Application No: WA/93/20/PL
Site Address: Land East of Tye Lane Walberton BN18 0LU
Description of works: Alternative vehicular access off Tye Lane & emergency access off Avisford Park Road, along with minor highway works following WA/95/18/RES. This site is in CIL Zone 2 (Zero Rated) as other development.

Thank you for your internet representation made on 20th January 2021 which has been recorded as an objection with the comments as follows:

AVISFORD PARK ROAD

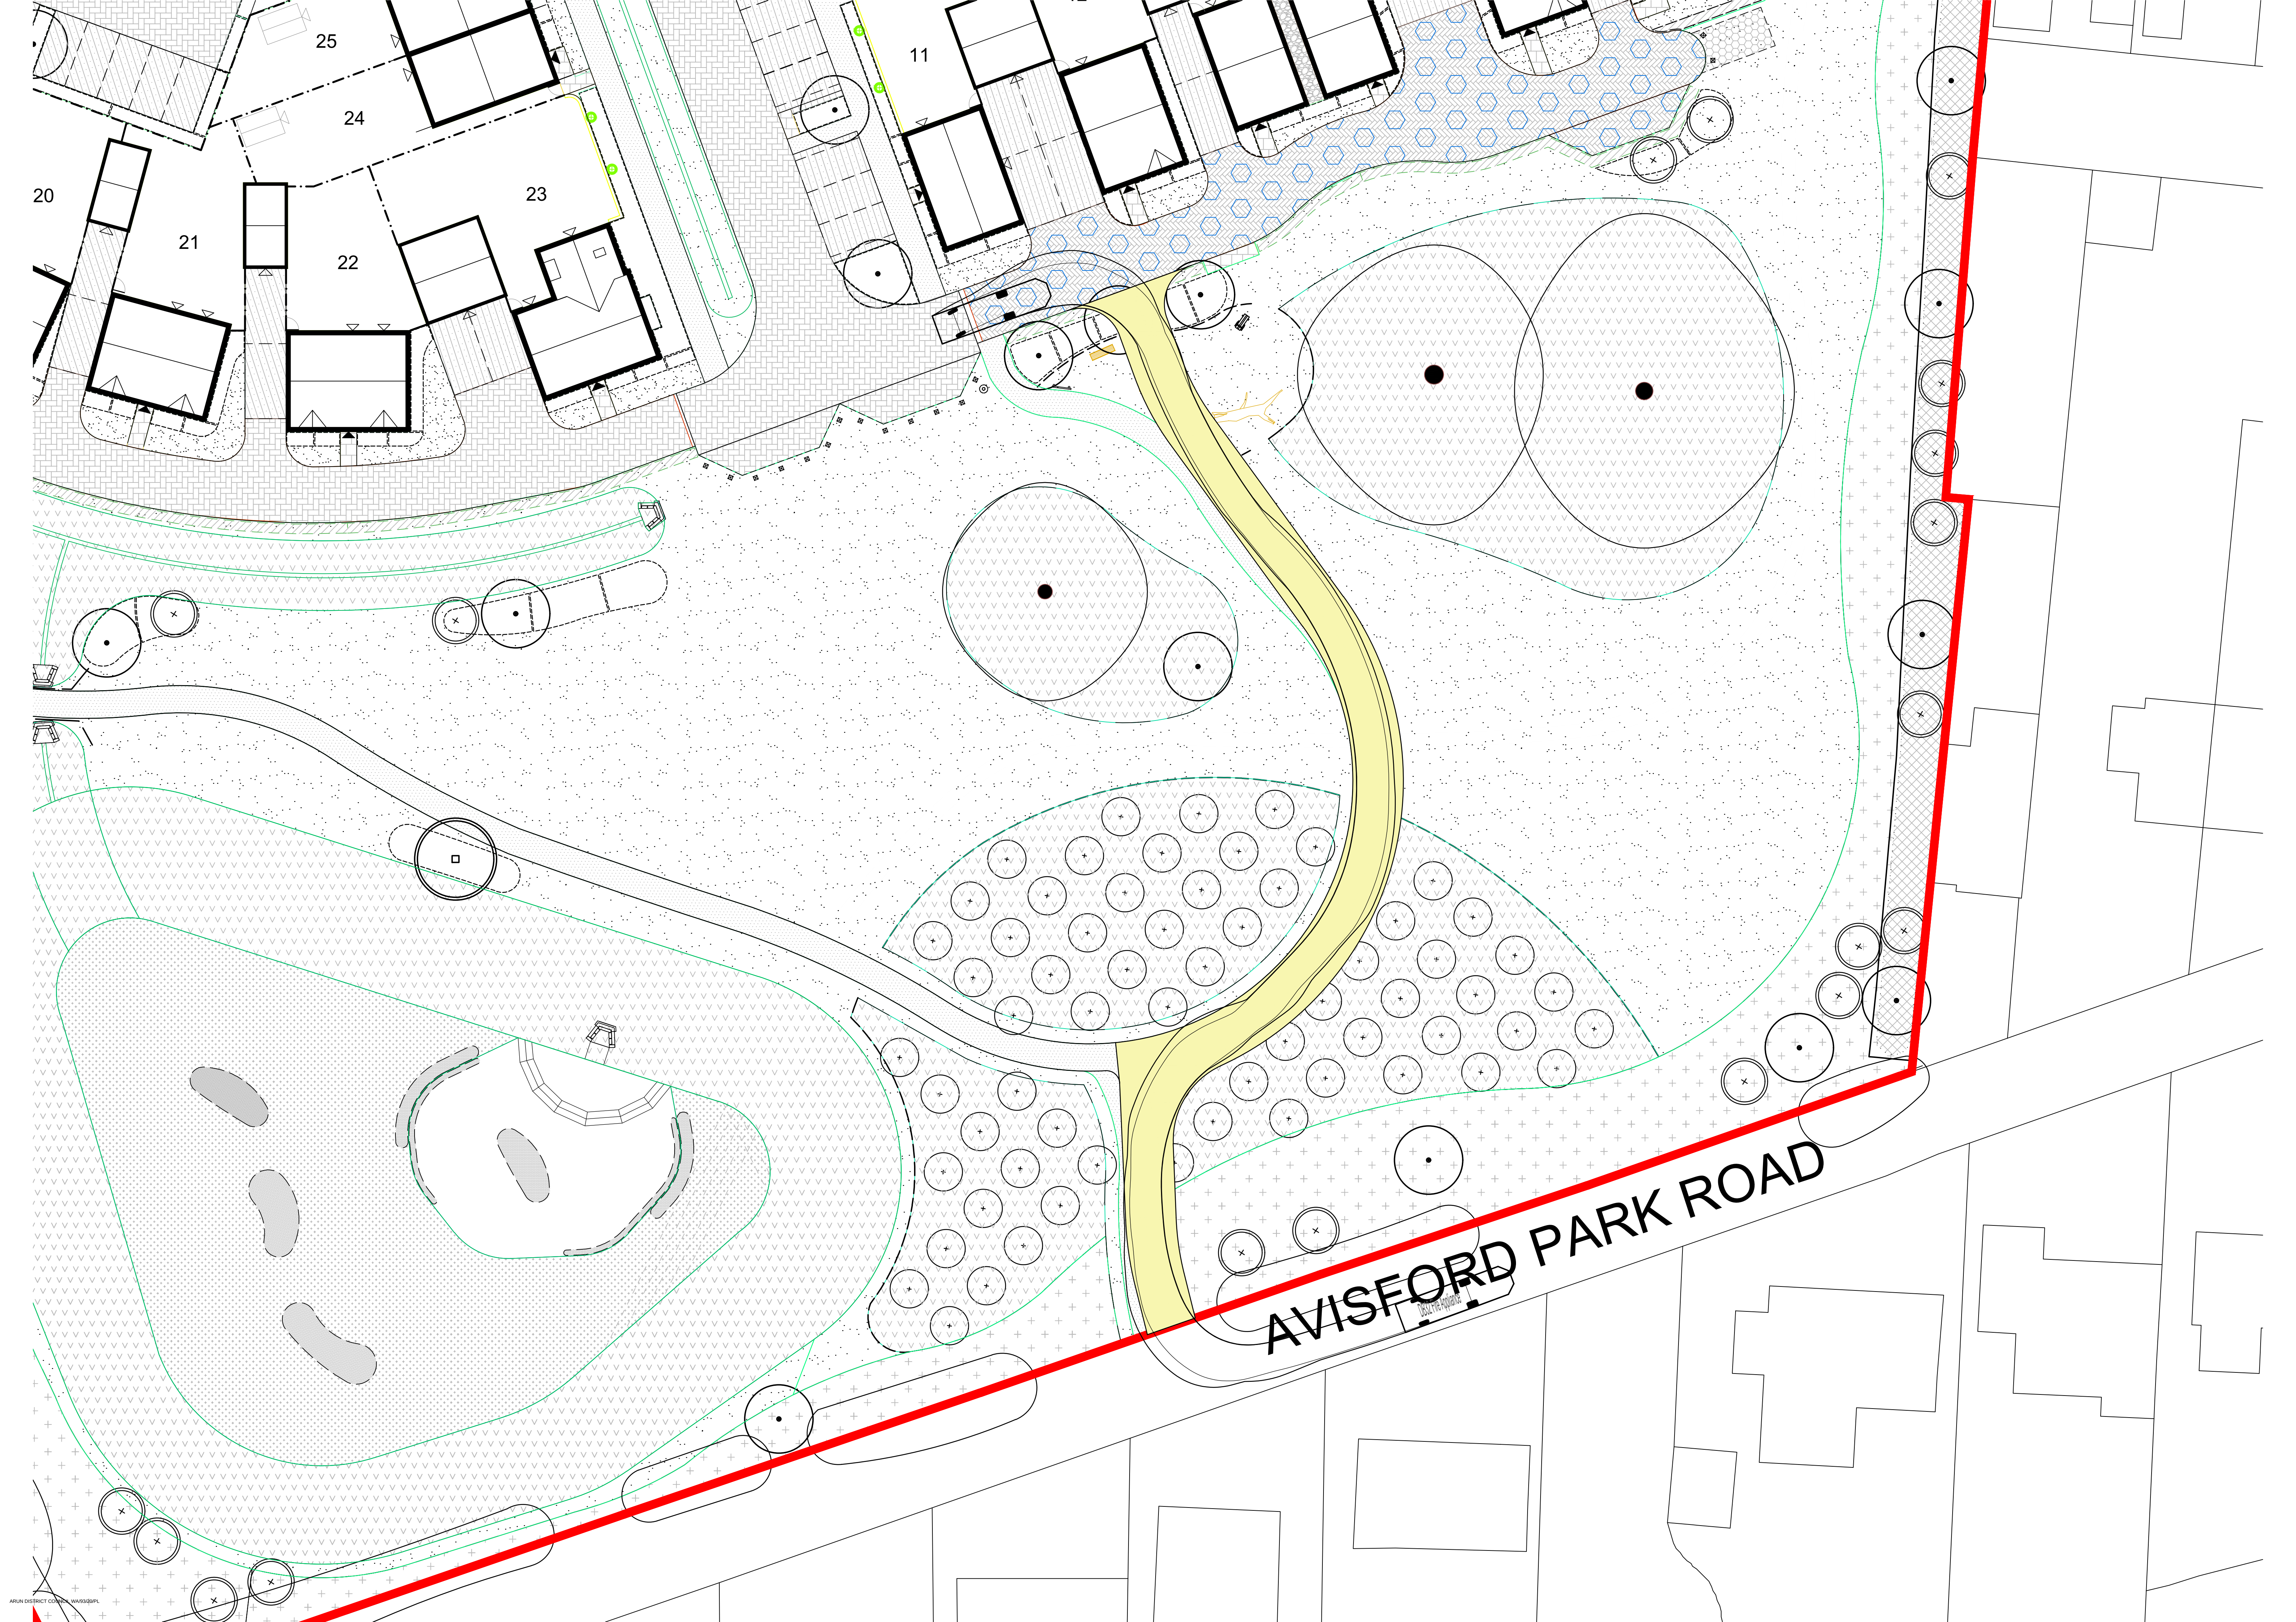
There is insufficient detail shown on the plan relating to the emergency gate. Certainly the position of the gate is shown, but there is no specification for it, most importantly whether it will be locked when not being used by

the emergency services.

The emergency gate is also shown in isolation. There is no indication of where the road goes from the gate, the specification for the road, how it links to the estate and which features of the park it compromises or destroys.

Why put the emergency access gate in Avisford Park Road at all? It would cross approximately 100m of newly designated community parkland to reach the estate.

What would the proposed gate look like? The gate directly faces houses in Avisford Park Road, so could easily be an eyesore if it and the access road beyond were not treated sensitively.
